Your reference: SSD-11826681 and  
SSD-11826621  
Our reference: DOC23/60225 and  
DOC23/60557

**Heritage NSW - Advice on Environmental Impact Statement (EIS) - State Significant  
Development (SSD-11826681 and SSD-11826621) – HVO North and South Open Cut Coal  
Continuation Project**

**Sam Gibbins**  
A/Manager Assessments  
Heritage NSW  
Department of Planning and Environment  
(As Delegate under *National Parks and Wildlife Act 1974*)  
Date: 27 February 2023

Figure 8 - Aboriginal heritage site CM-CD1

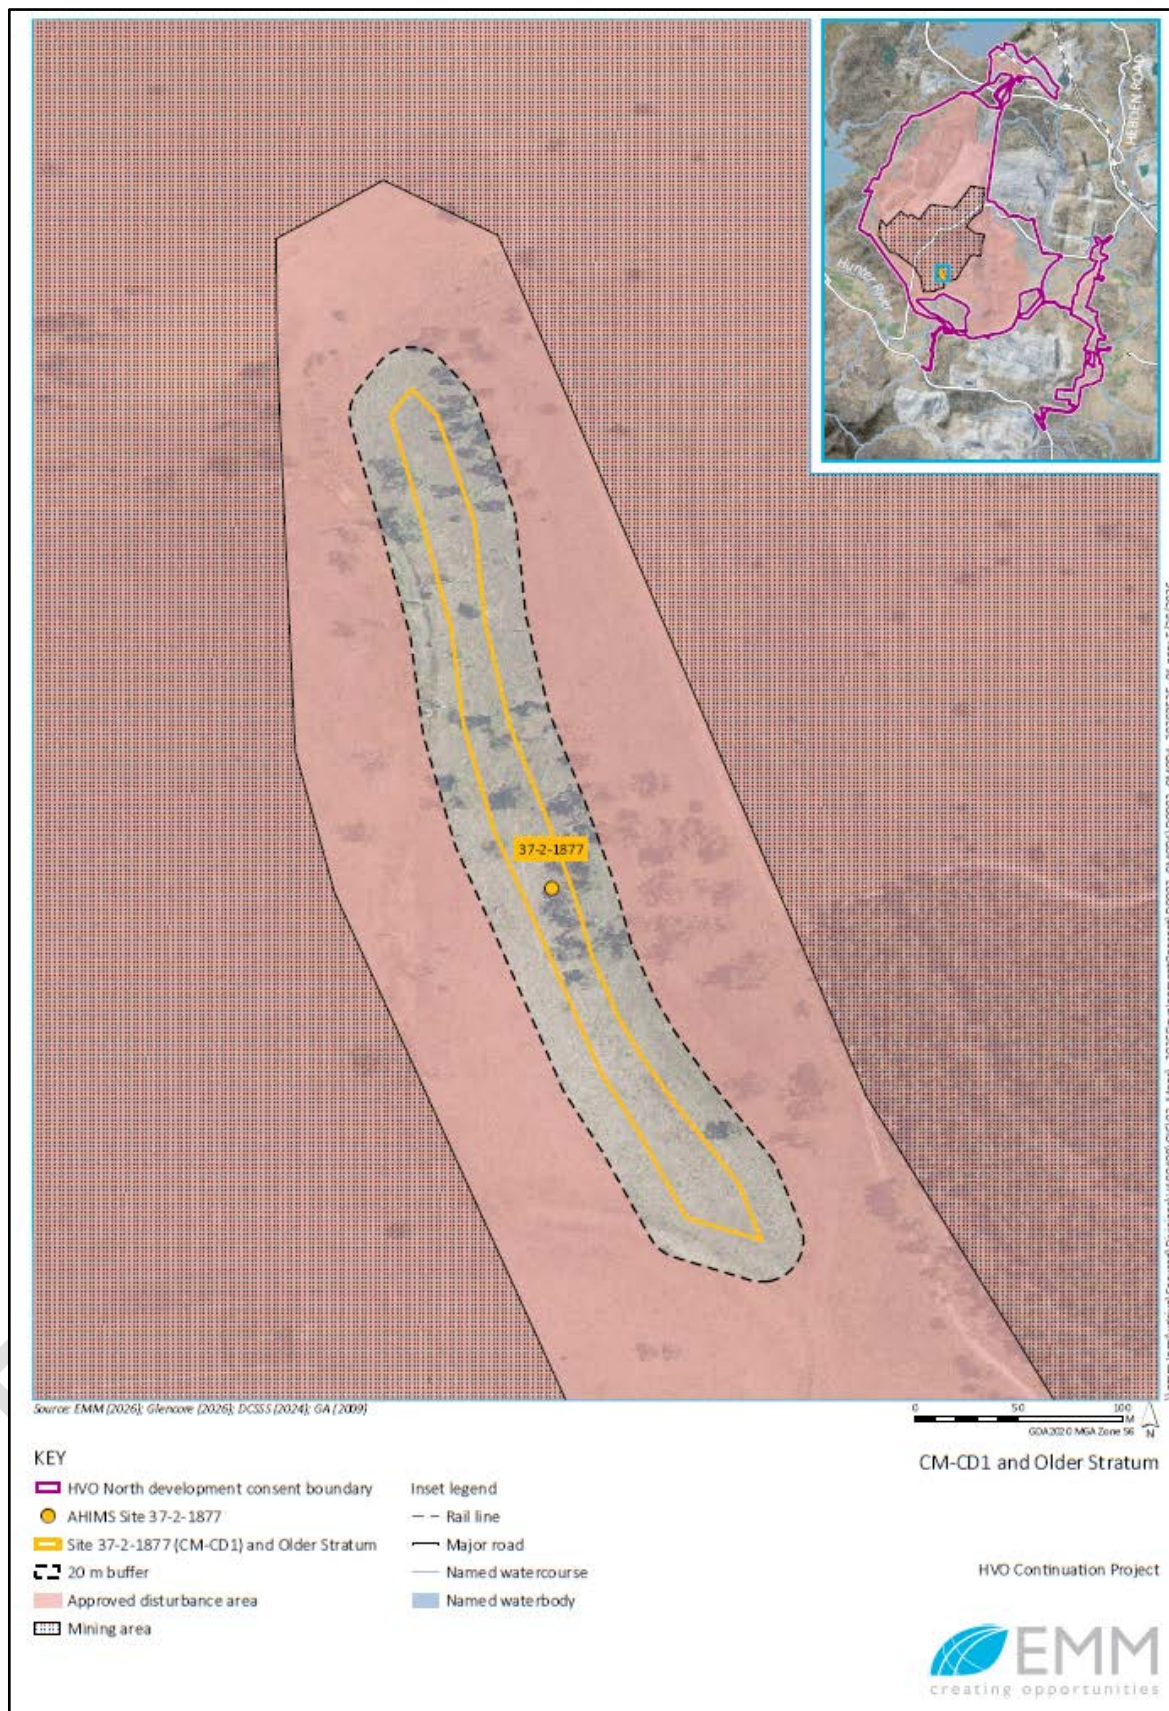
- Undertaken as a requirement of the SEARs was the re-excavation and dating of AHIMS site #37-2-1877 (Carrington Mine Colluvial Deposit 1 [CM-CD1]), which identified that the lower deposits dated between ~9,000-16,000 years ago. The test excavation program across the project area identified four areas (5, 9, 11, and 12) that contained a minimum of 50 cm of sediment and relatively high numbers of artefacts. However, the ACHAR did not discuss whether, in light of the results from CM-CD1, these four areas had the potential to contain Pleistocene deposit.

- Further information is also required on the extent that the landform associated with CM-CD1 may extend further into the disturbance area and whether any potential sub-surface archaeological deposits may be impacted.
